From: Tracey Headley-Smith
Sent: 12 November 2018 15:39
To: Karen Parsons
Subject: FW: WA/73/18/HH 2 Parsons Walk Walberton

DRAWING No MK/1819/900/2

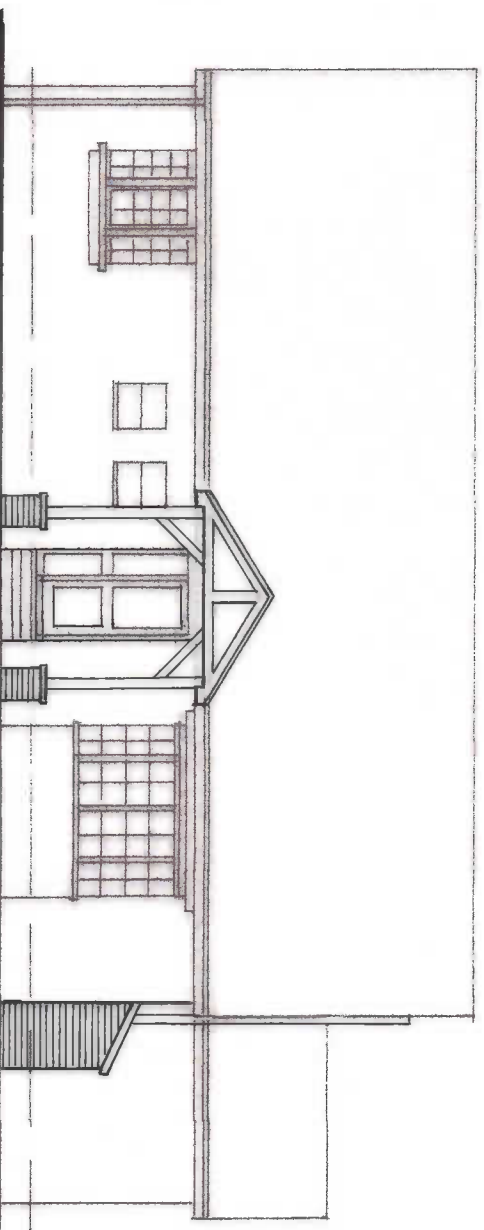
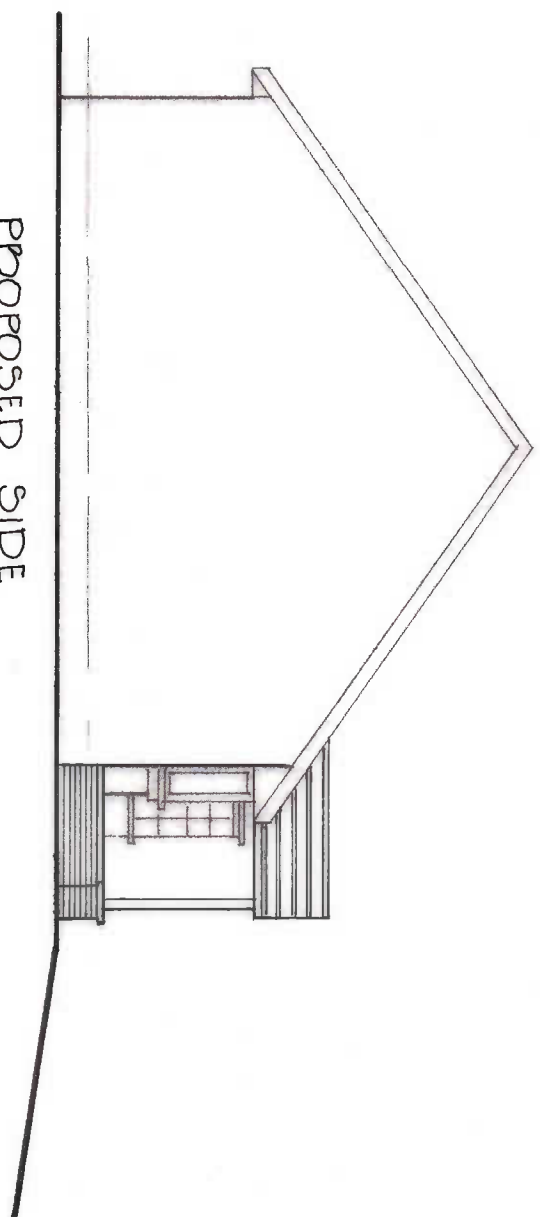
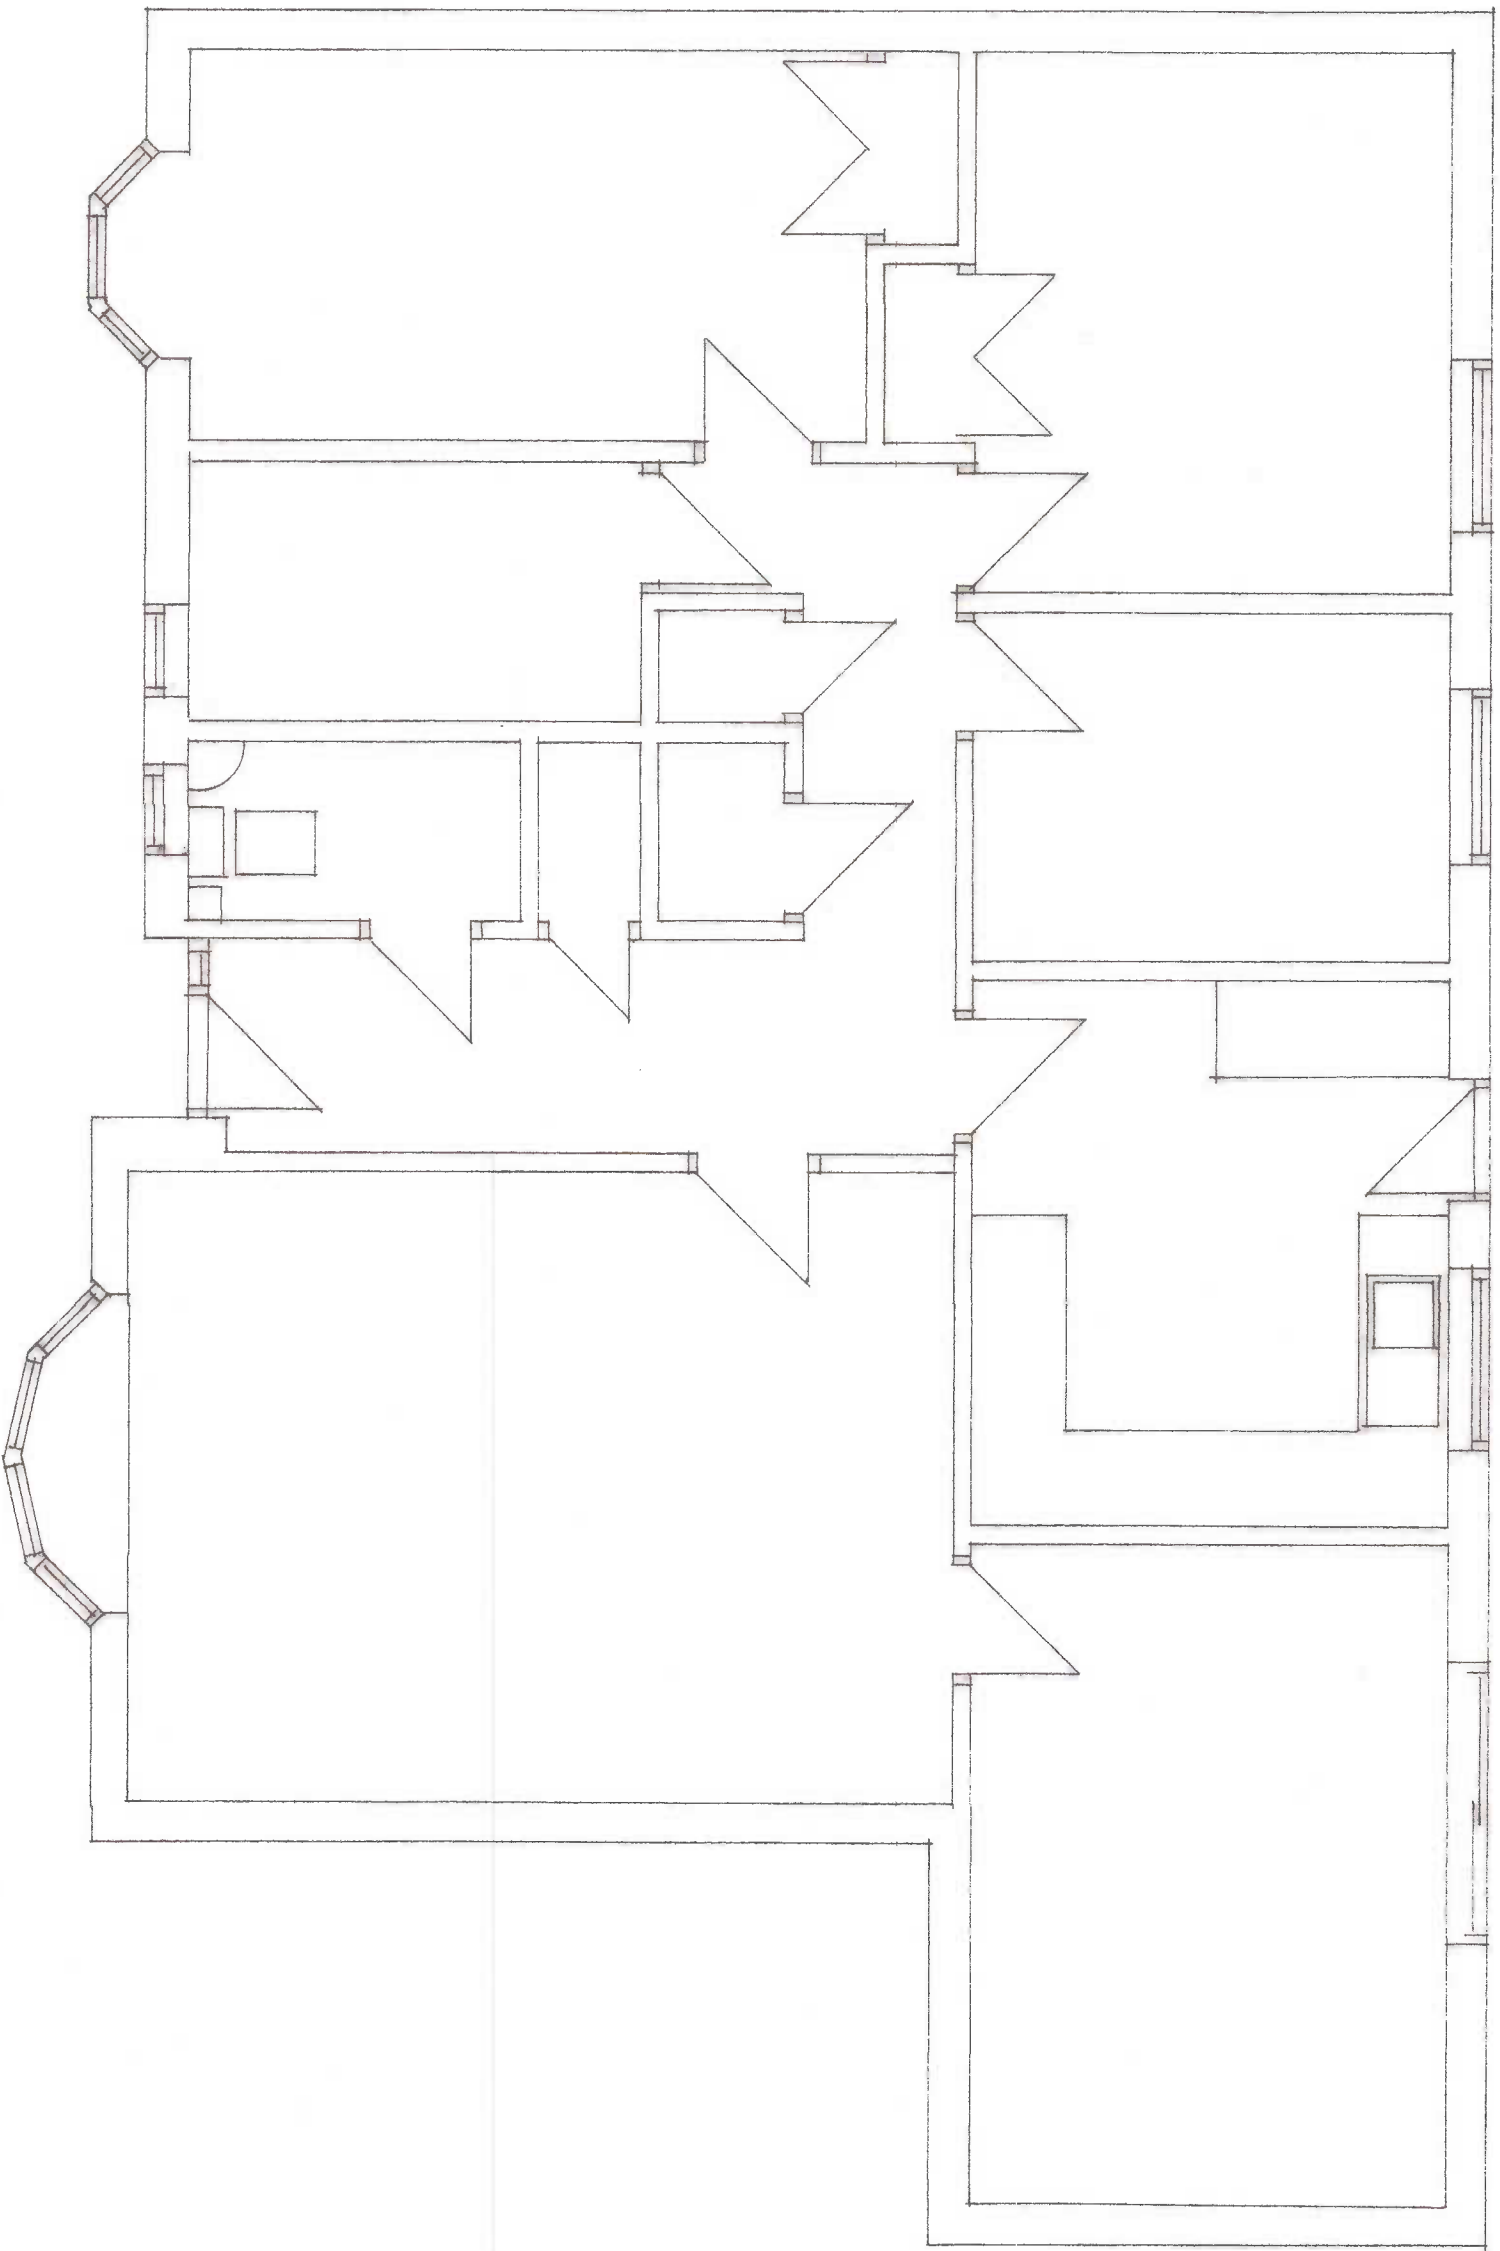
In assessing the above application, I note that reference is made to the flue being terminated at a height 'to be determined by the manufacturer' This detail will be required before determination of the above application, also the finish/colour of the flue.

Having discussed the route of the flue with the applicant, I have attached a new elevation (revision B) showing the flue directed toward the ridge before rising vertically. This reduces the projection above the roof plane to the minimum of 600mm, but not above the ridge, as required by the Building Regulations.
